DRB Application No.: 06DRB-01475 (P&F)

Project Name: BANK OF ALBUQUERQUE

**CITY OF ALBUQUERQUE
PLANNING DEPARTMENT
October 18, 2006
DRB Comments**

RE: Lots 15 & 16, Block 9, Tract 2, N.A.A. Unit 3/p&f

PLAT OF  
 LOT 16-A, BLOCK 9, TRACT 2, UNIT 3  
 NORTH ALBUQUERQUE ACRES  
 PROJECTED SECTION 18, T. 11 N., R. 4 E., N.M.P.M.  
 ELENA GALLEGOS GRANT  
 CITY OF ALBUQUERQUE  
 BERNALILLO COUNTY, NEW MEXICO  
 SEPTEMBER 2006  
 SHEET 2 OF 2

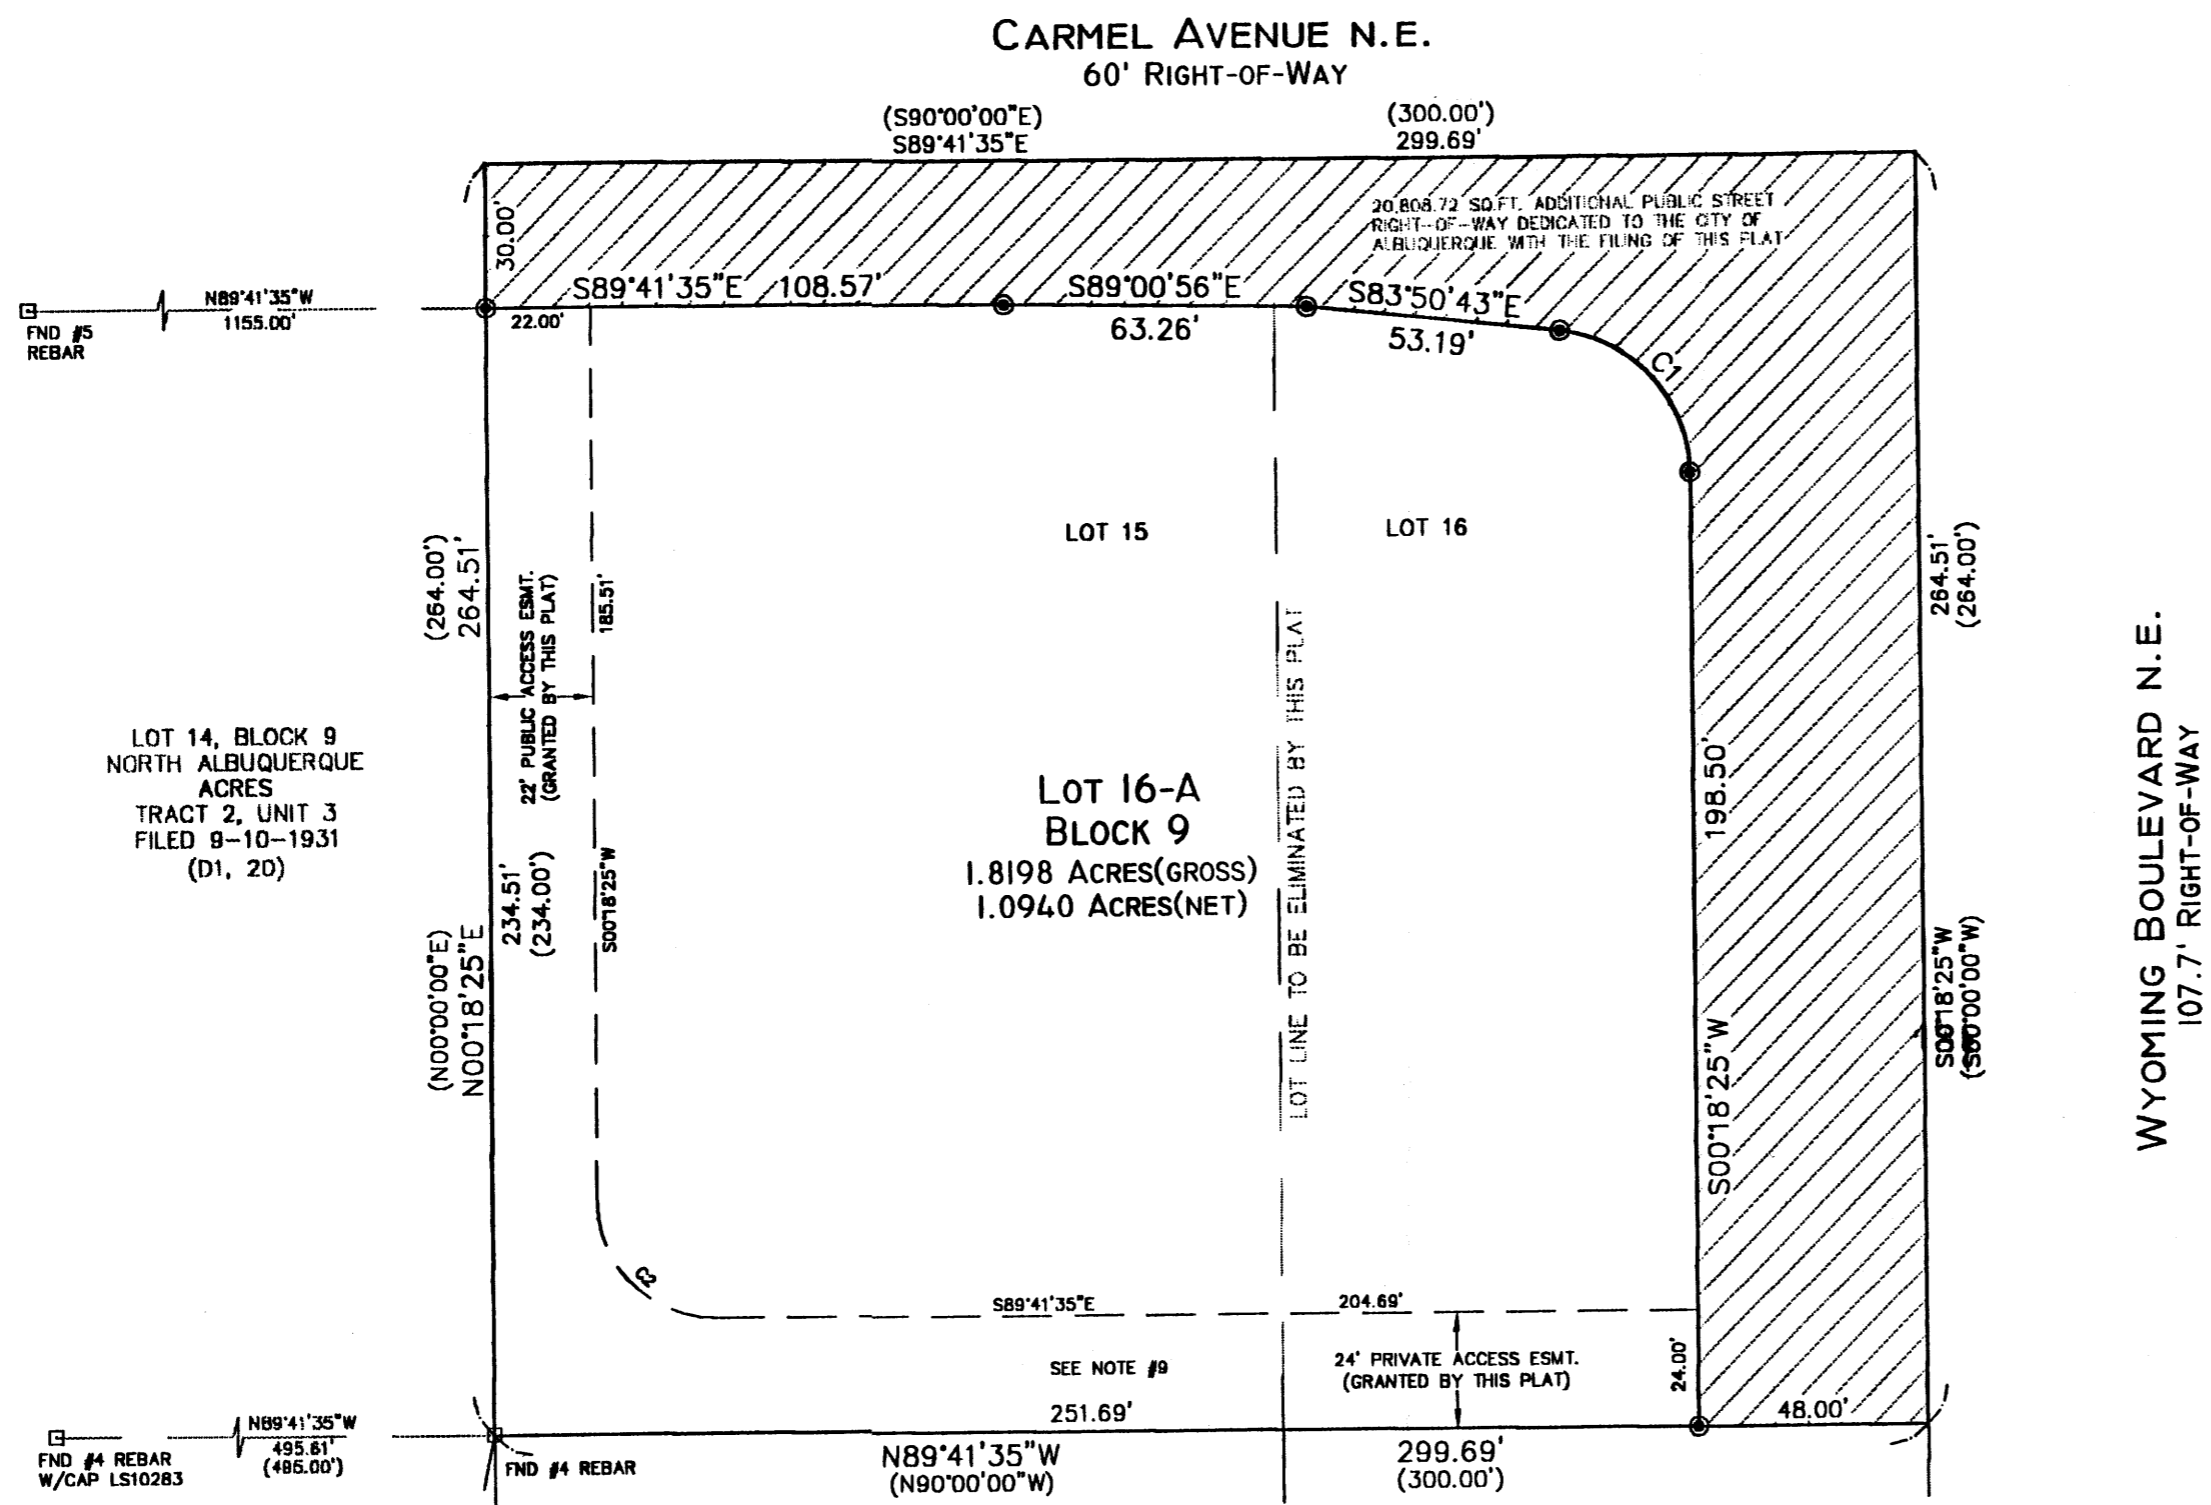
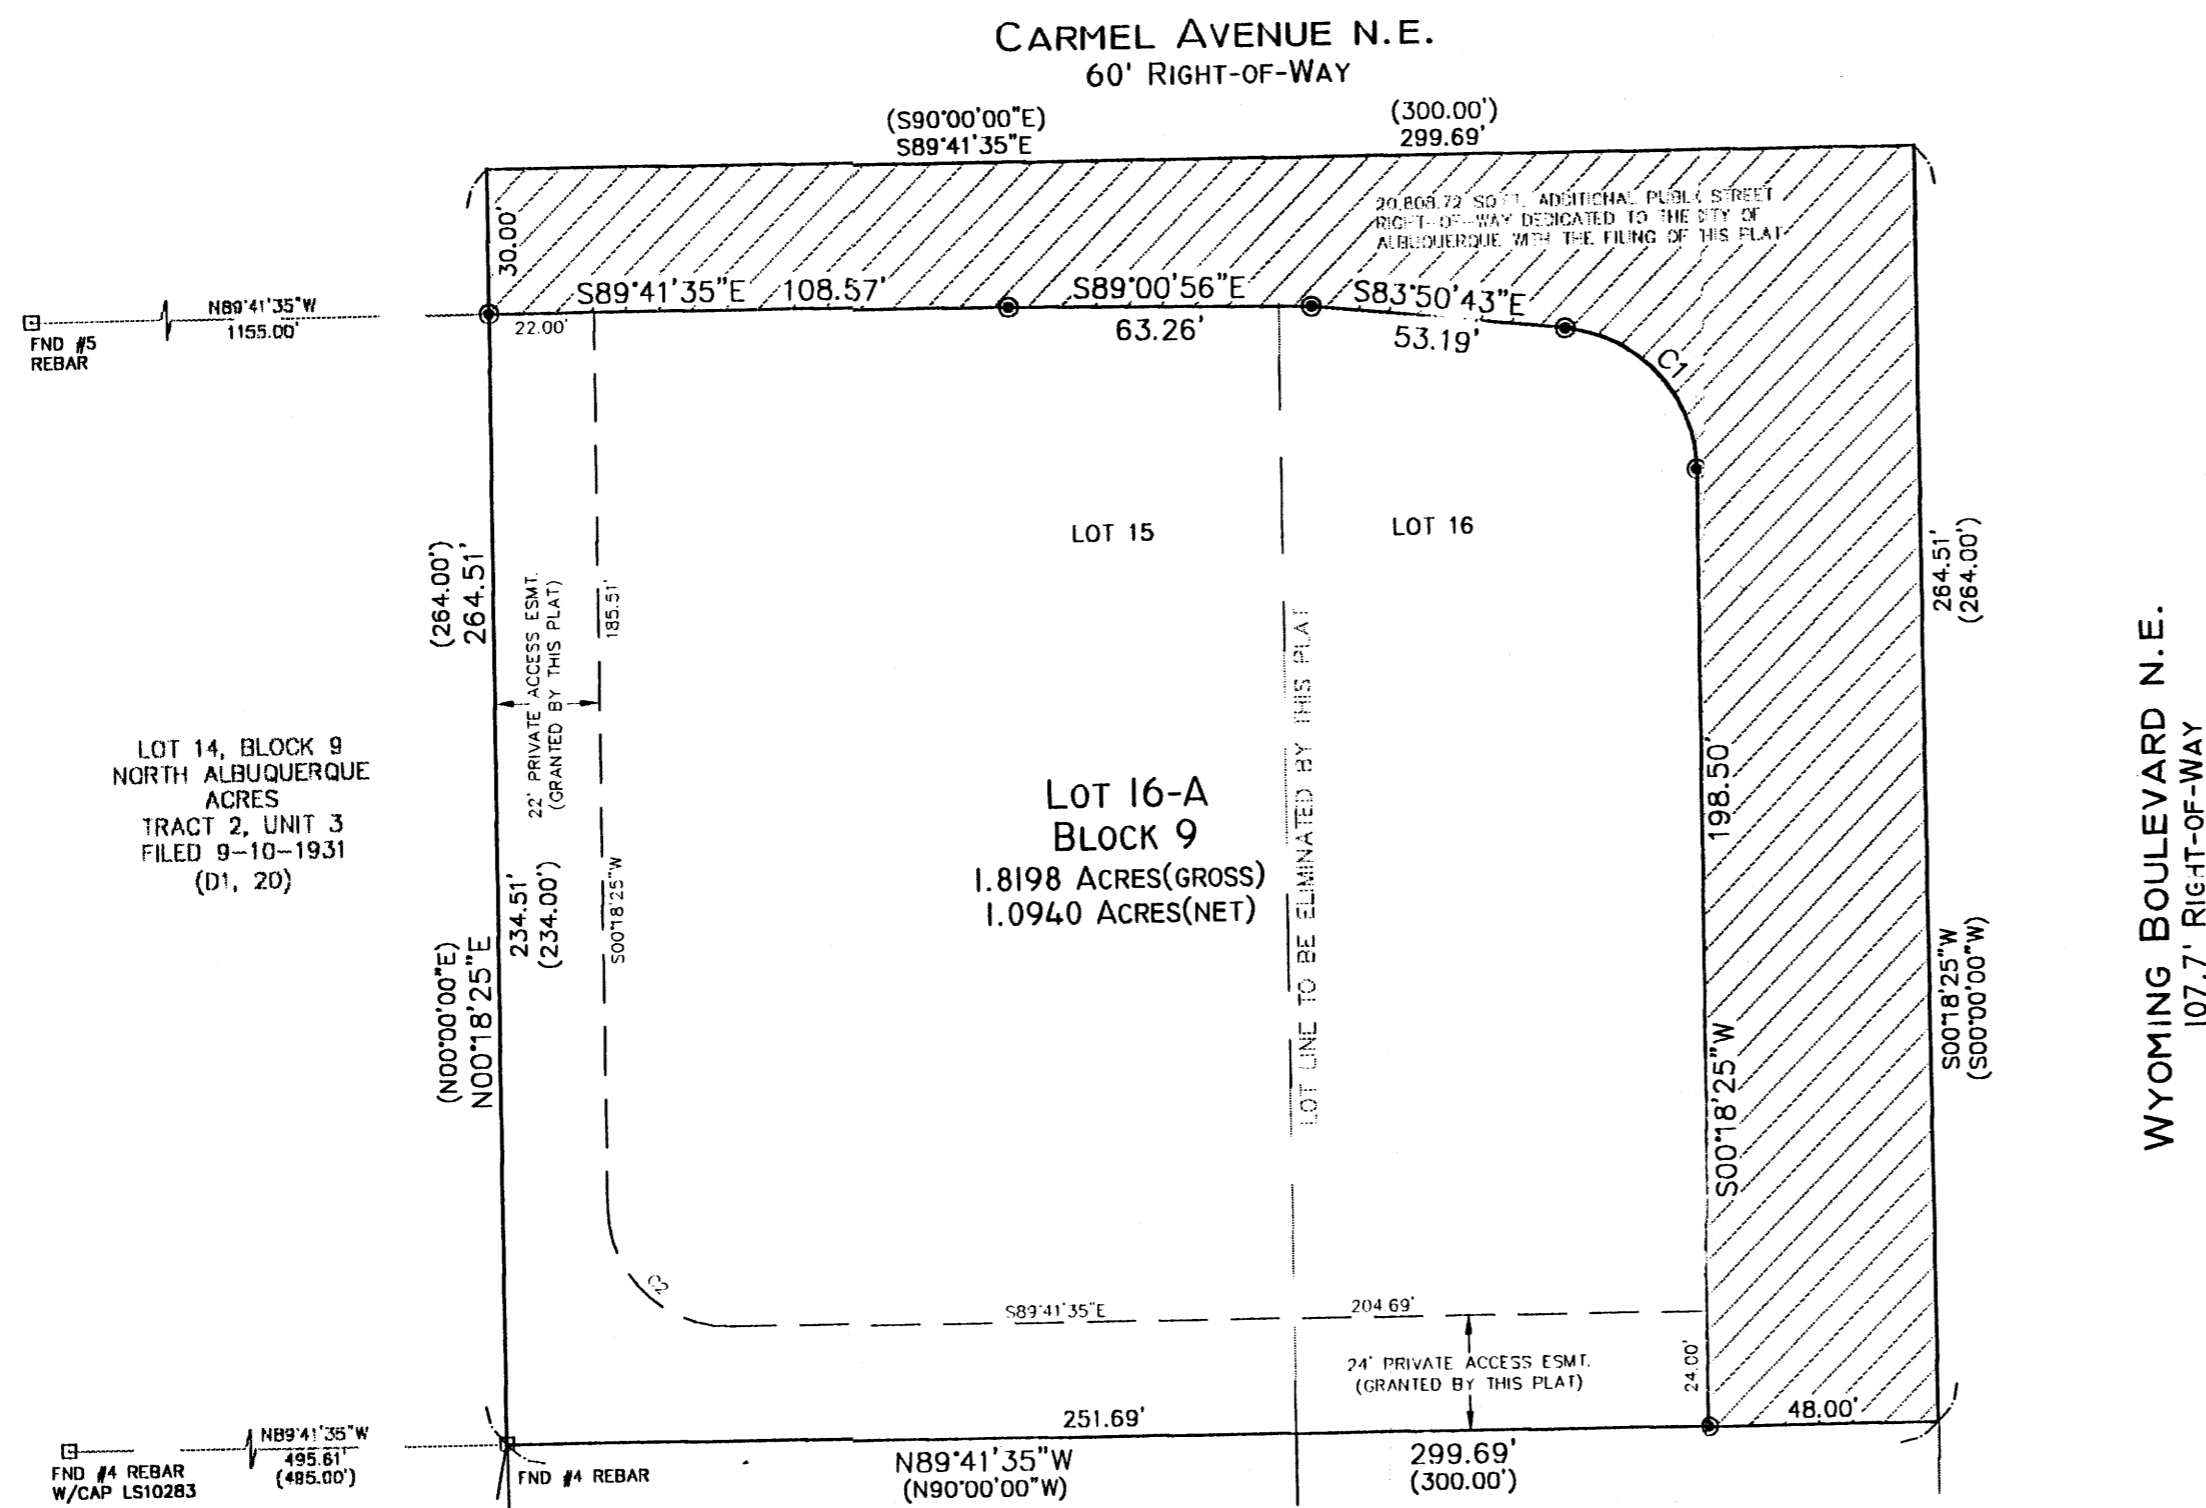
- TRANSPORTATION: - EASEMENT FOR ADA RAMP ON LOT 17 ✓ ok ✓
 - MAINT. & BENEF. of 22' & 24' ACCESS ✓
 EASEMENTS

Lot acreage on the plat (1.8198) do not match the acreage on the Site Development Plan (1.613).

APPROVED WITH FINAL SIGN OFF DELEGATED TO CITY ENGINEER FOR SIA AND PLANNING FOR 3 COPIES OF THE SITE PLAN AND CORRECT ACREAGE TO MATCH PLAT.
